SOUTH HOLLAND DISTRICT COUNCIL

To: Planning Committee - 14 April 2021

Purpose: To consider Planning Application H16-0208-21

Description: Proposed 18m Phase 8 Monopole C/W wrapround cabinet at base and associated ancillary works

Title: 260 PROPOSED H3G ELEVATION

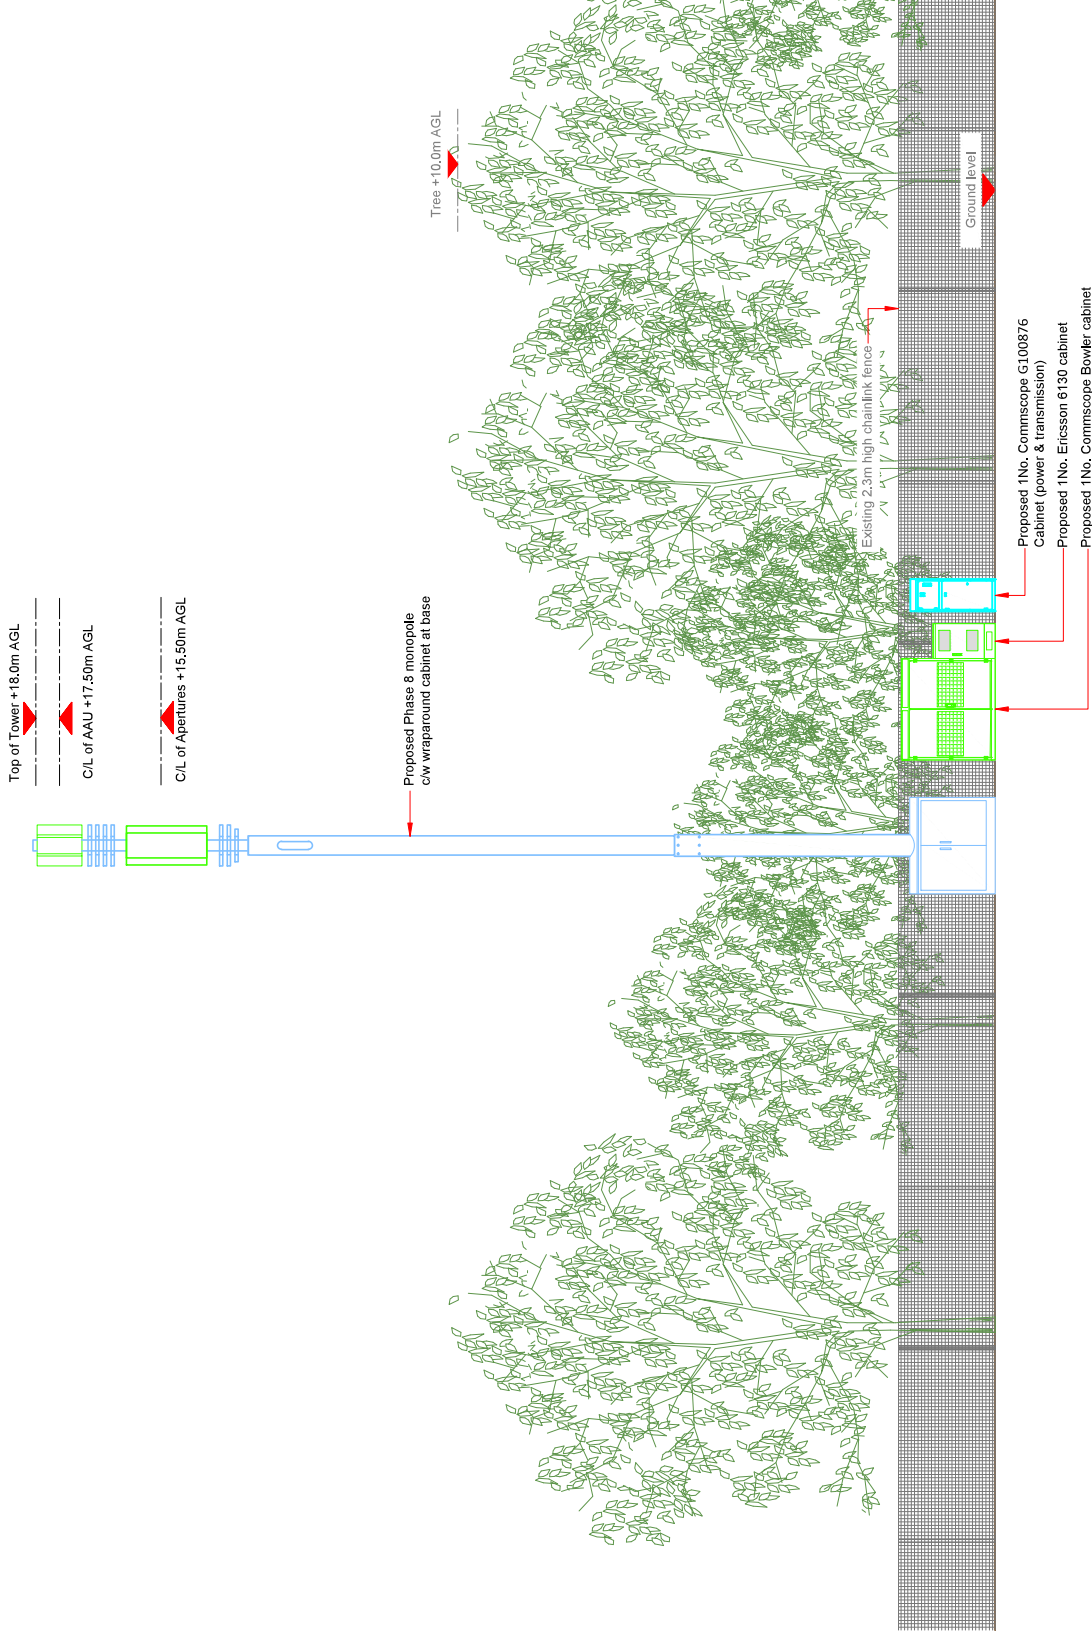
7.12 In terms of its siting, the proposed monopole, at 18 metres in height, would be visible in the street scene and the scale is not comparable to any other structure or building in the vicinity, being above the tree line and roof line of properties in the vicinity. However, it is considered that the applicant has attempted to minimise the visual impact of the mast and cabinets by siting them approximately 0.25 metres from the 2.3 metre high chain-link fence to the rear of the grassed area and against the backdrop of adjacent/nearby trees to the north and east. They would be 3.2 metres at the nearest point from the footway and there are also existing items of street furniture in the vicinity (street lamps and road signs) which form part of the street scene. In the context of this, it is the view of officers that the proposal would not materially adversely impact the character and appearance of the area.

- 7.14 In terms of appearance, the proposed mast and associated cabinets are of a functional design and a typical appearance of such communications infrastructure. It would likely be impractical for them to be designed in a different way.

210 PROPOSED H3G SITE PLAN

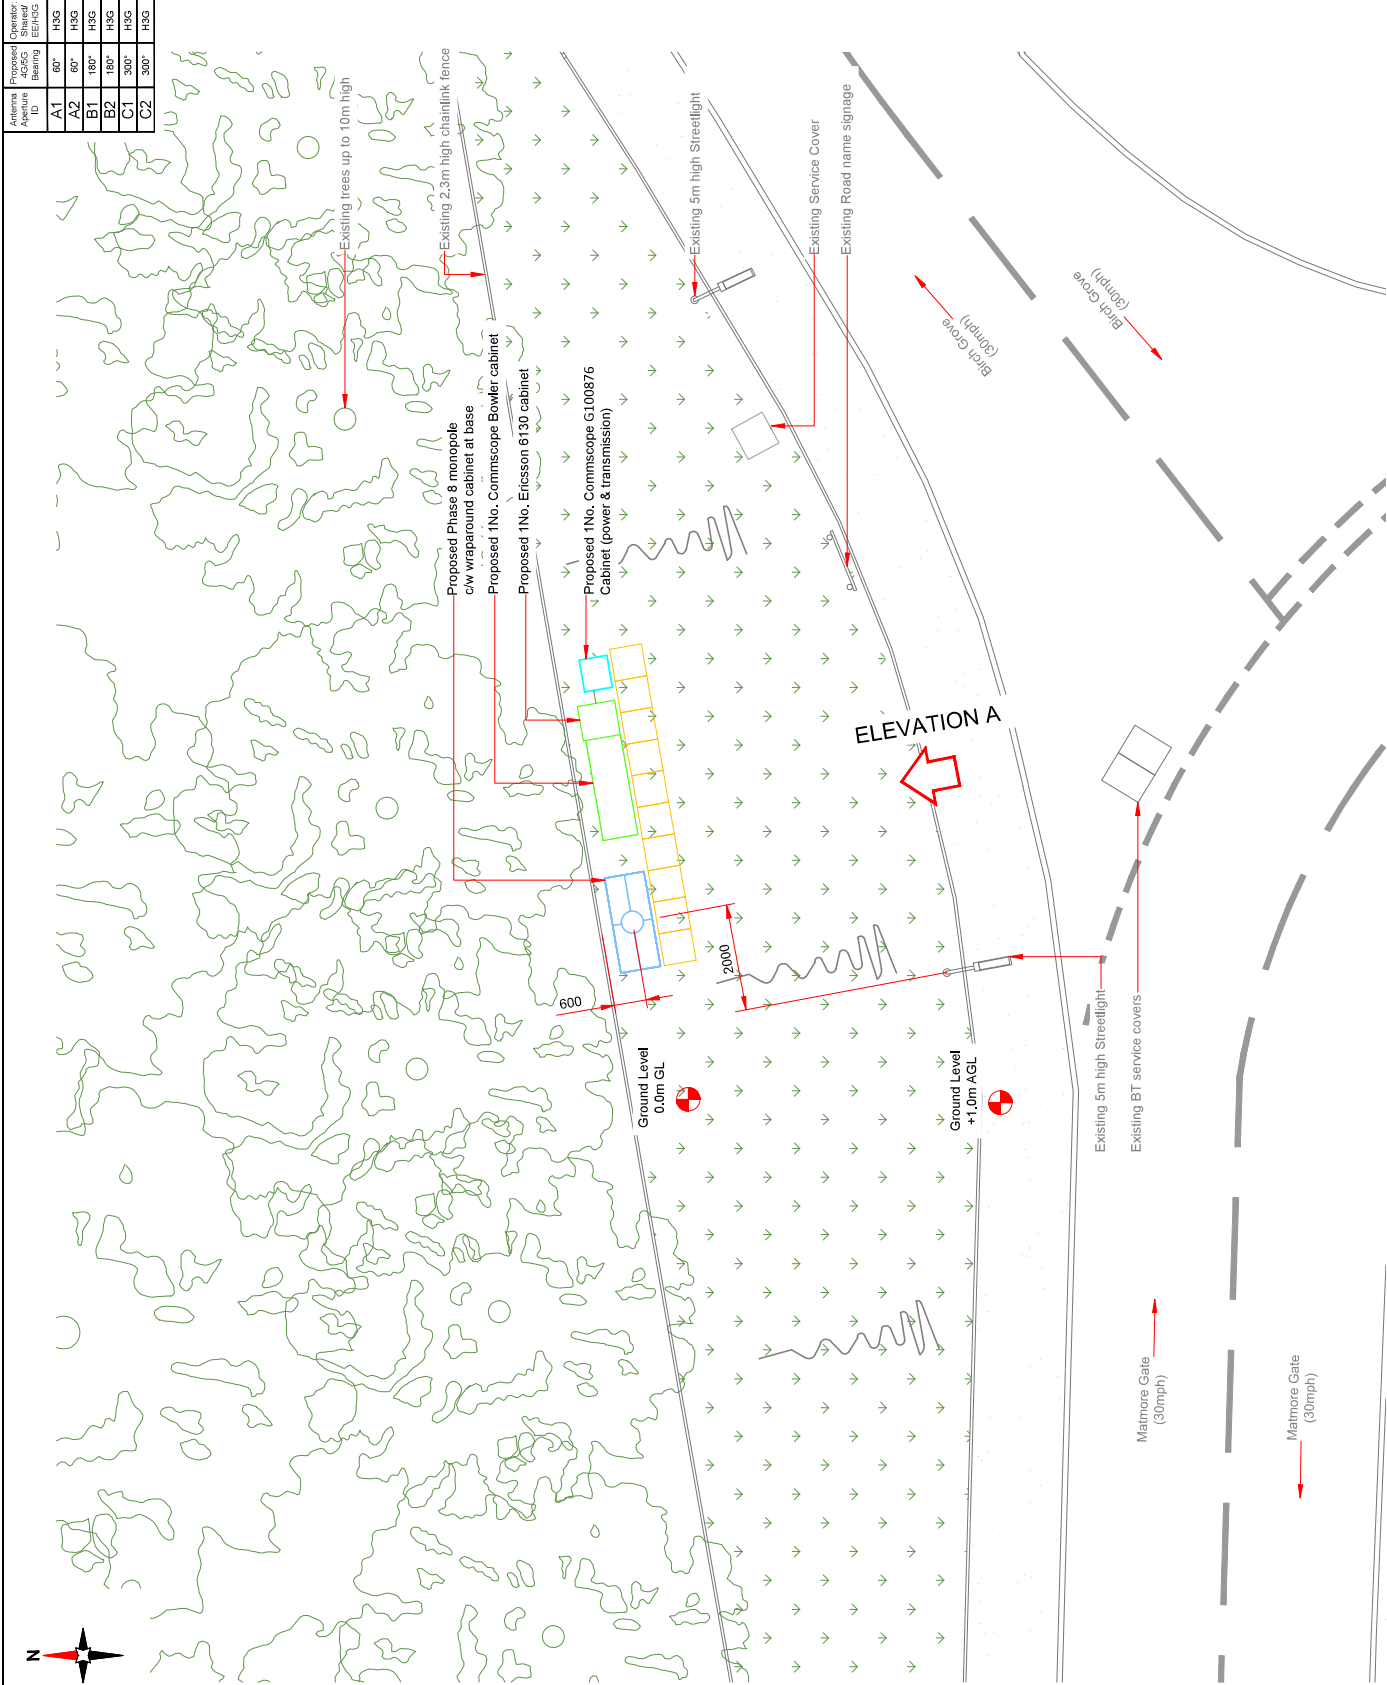
"The proposal is for a proposed 18m phase 8 monopole wrapround cabinet at base and associated ancillary works and it does not have an impact on the Public Highway or Surface Water Flood Risk. The monopole and cabinets have been set back which does not impede visibility at the junction and therefore, it is considered that this proposal will not have an adverse impact on highway safety"
